## Application by Four Ashes Limited for an Order Granting Development Consent for the West Midlands Interchange

### The Examining Authority's written questions and requests for information (ExQ1)

Issued on 4 March 2019

Figure 12.6 **A**

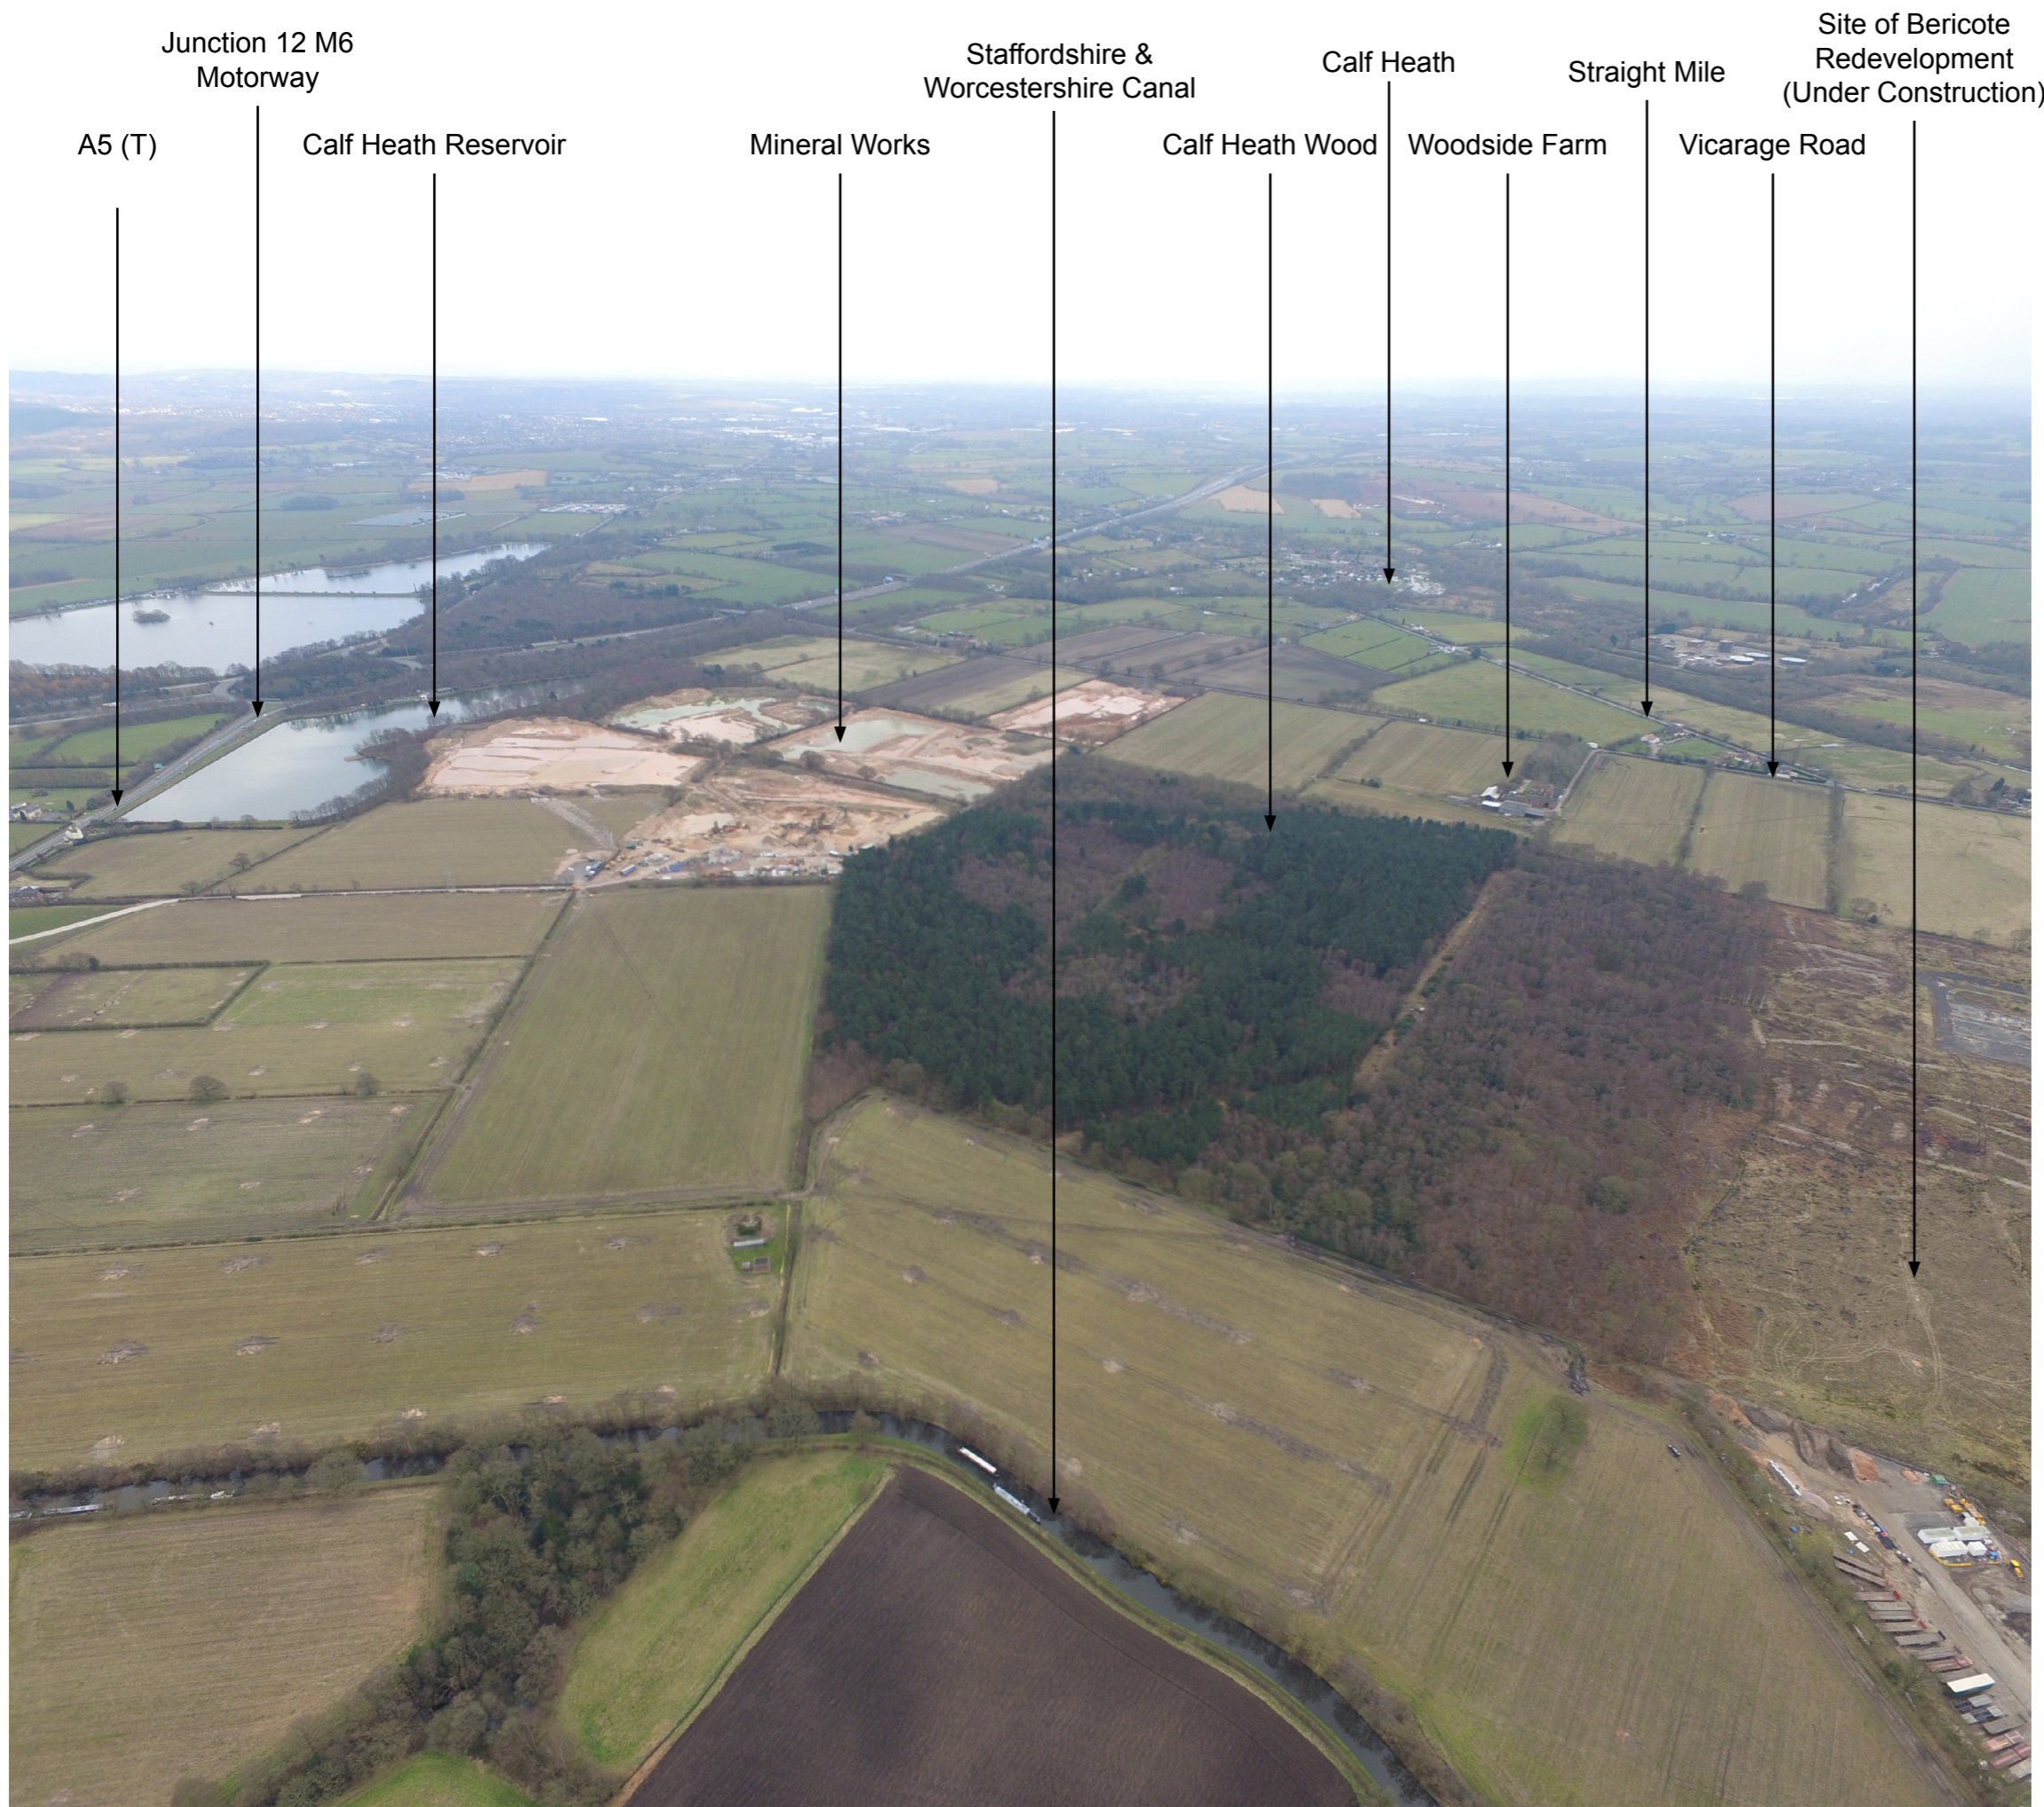
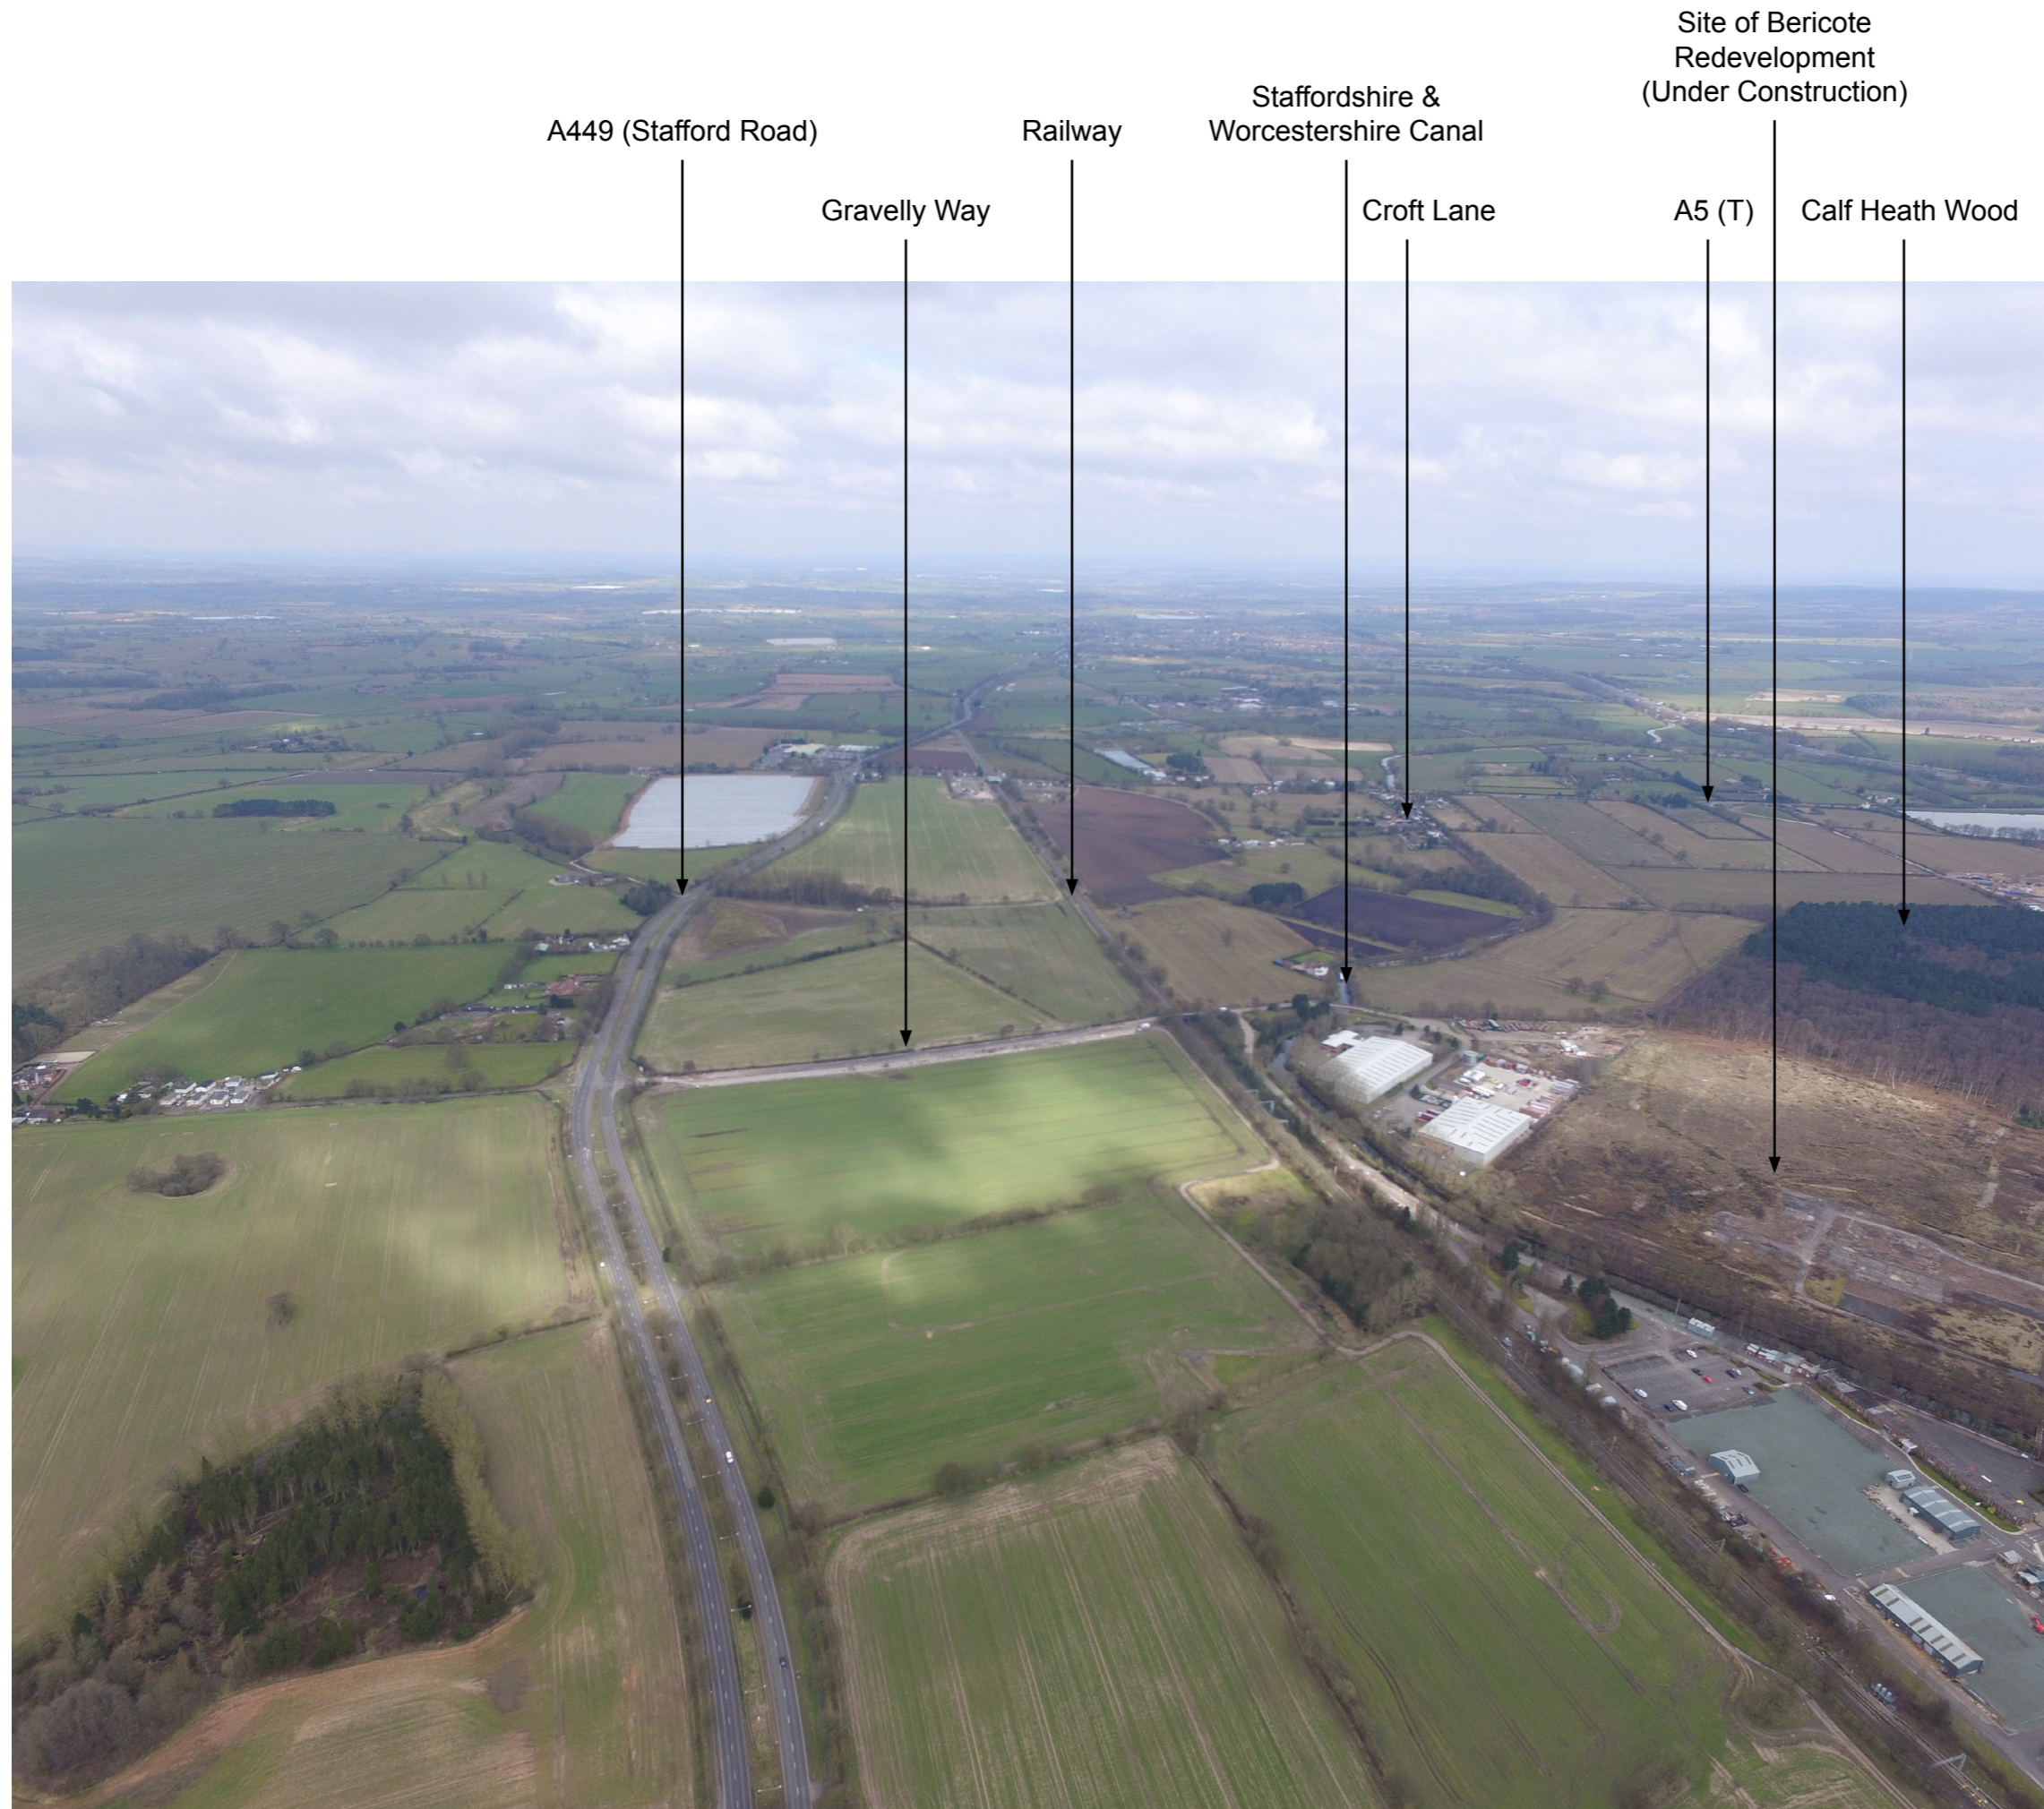
| ExQ1  | Question to:                             | Question:  |
|-------|--|--|
| 1.0.1 | The Applicant and SSDC                   | <p><b>Existing Land Uses.</b><br/>                     Some of the base plans used in the submission include the notation '<i>Caravan Park</i>' on land to the west of Croft Lane. This use is not evident on the aerial photographs in ES Figure 12.6 and does not appear to have been referenced or considered in the ES.</p> <p>(i) Does the use still exist and, if so, does it include any permanent residential use?<br/>                     (ii) If not, is there a planning permission in place or other means by which such a use could be resumed or resurrected in this location and could this include any permanent residential use?</p> |
